Rezoning Transportation Analysis

Petition Number: Insert Zoning Petition #2020-181

General Location Identifier: 11122105

REZONING PLAN

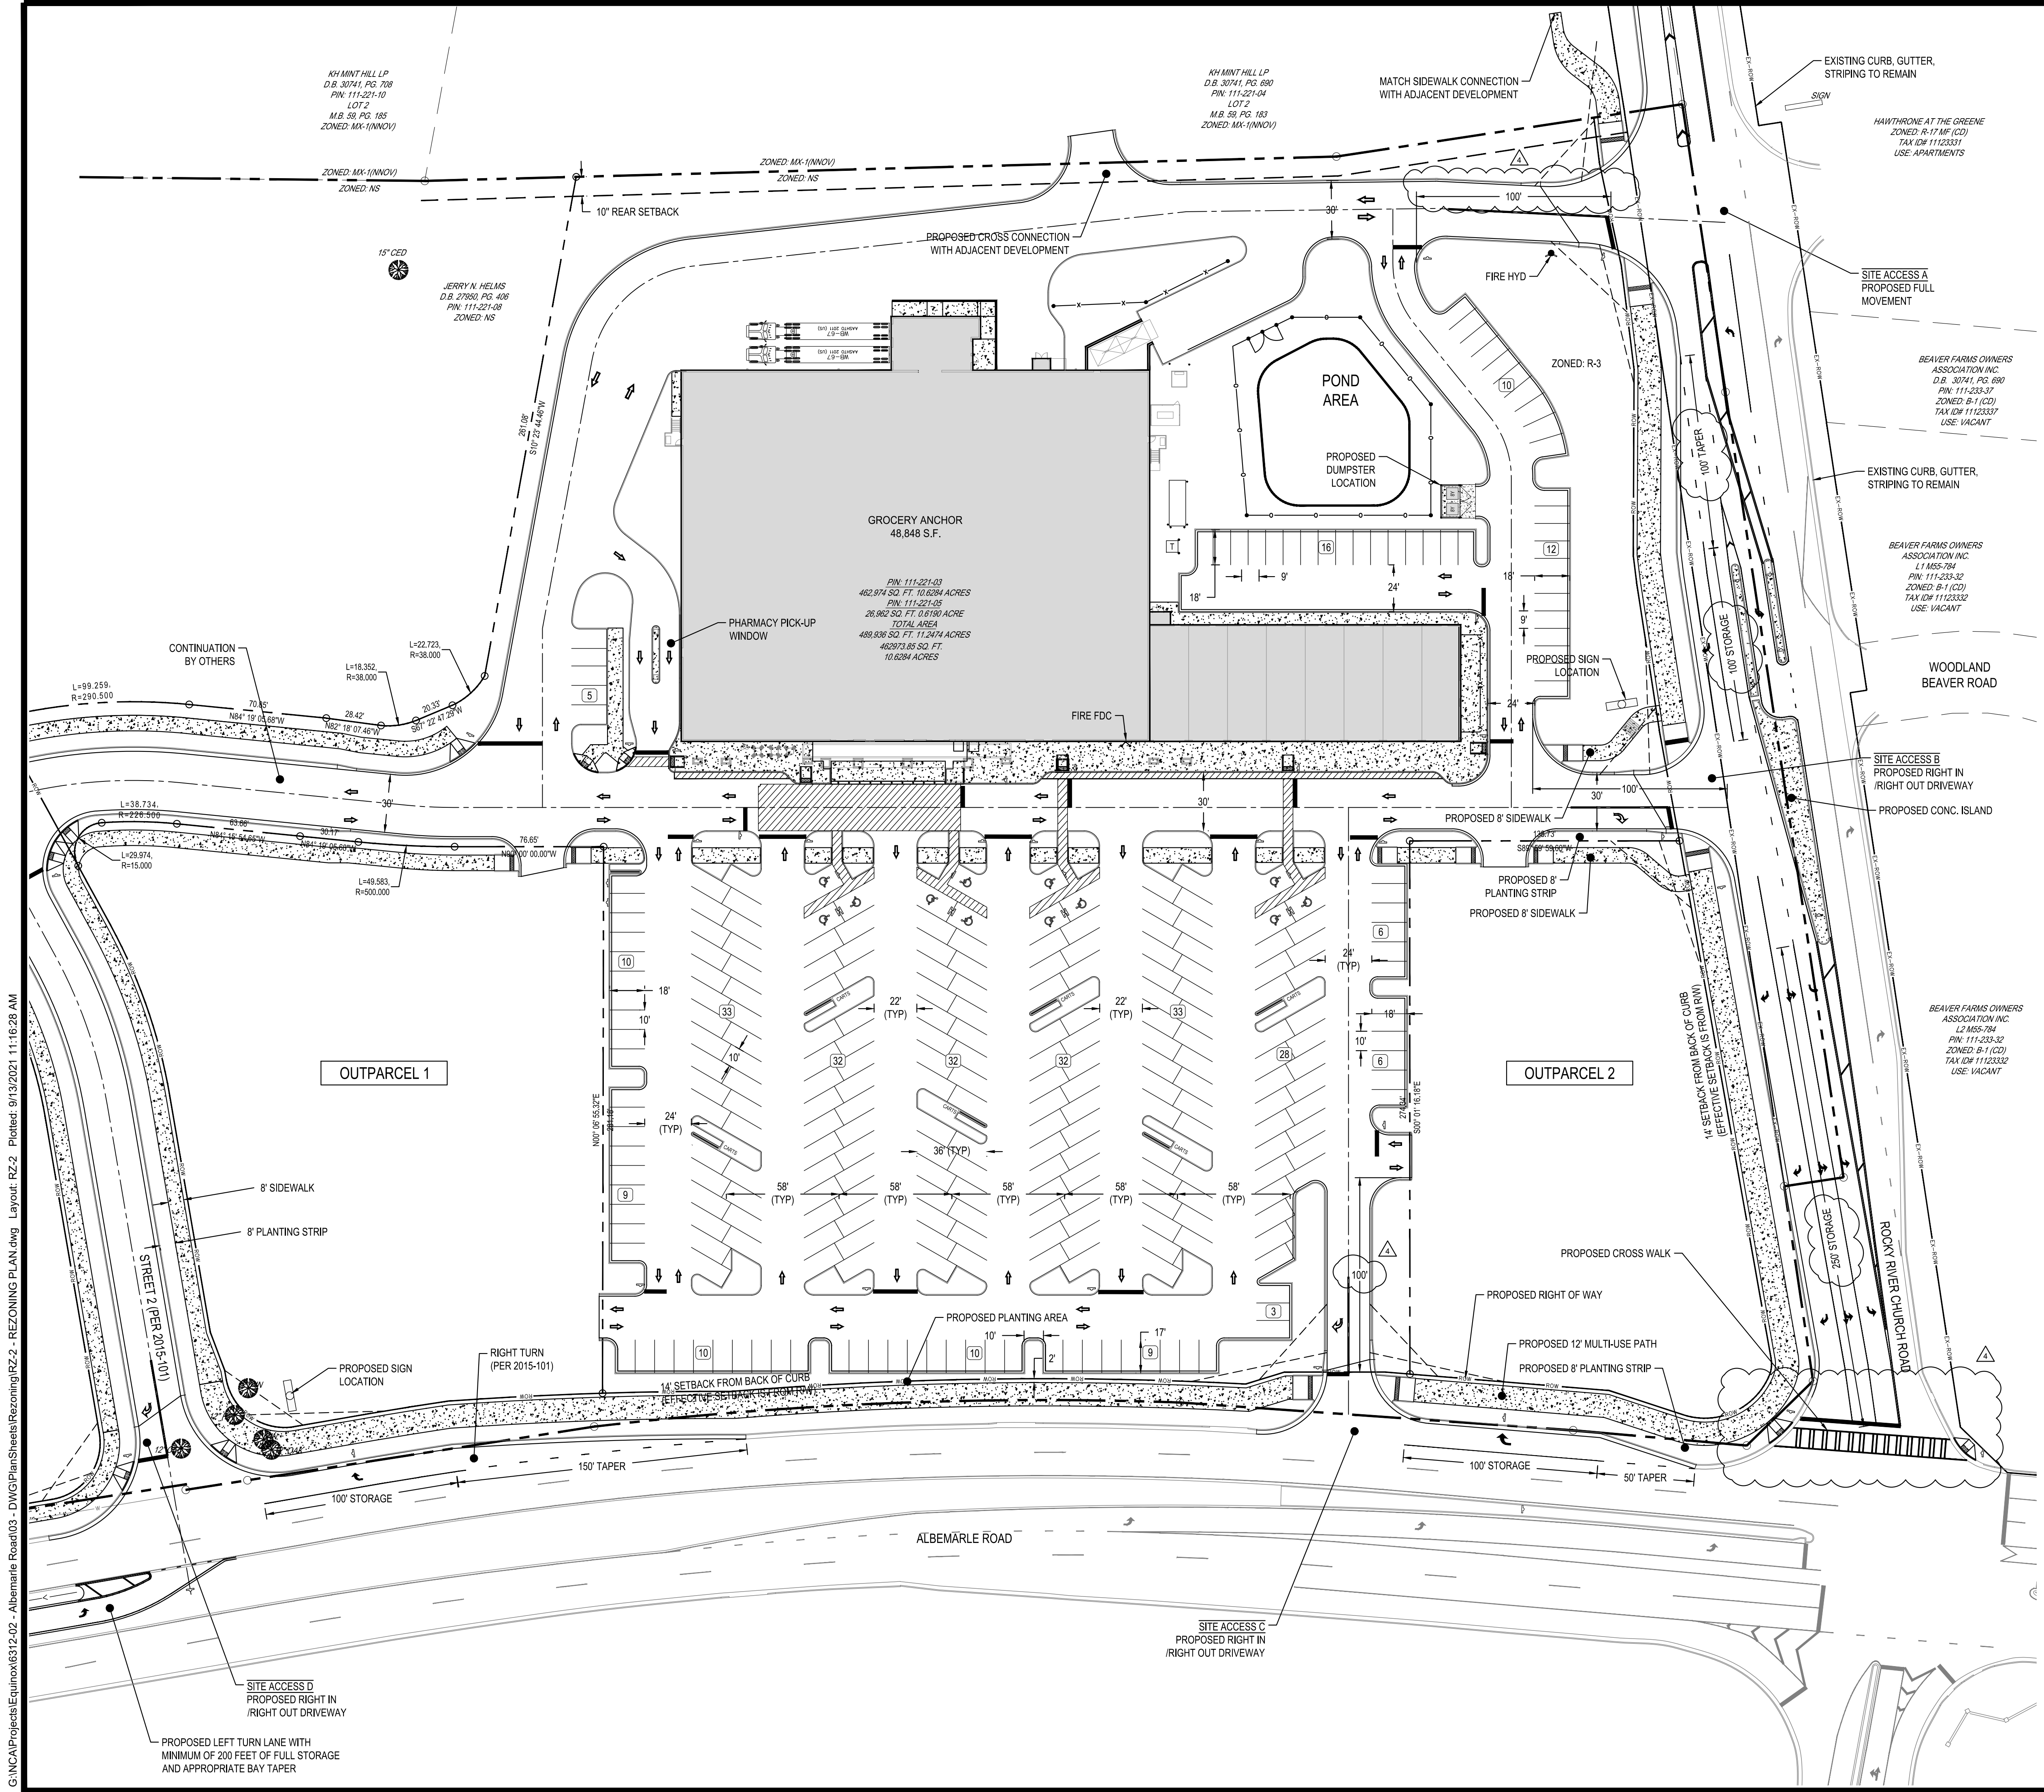
9. **New Comment (based on NCDOT email dated 09/21/21):** Revise site plan and conditional notes to reserve an additional 12' right-of-way along the frontage of Rocky River Church Road to accommodate a future roadway widening.
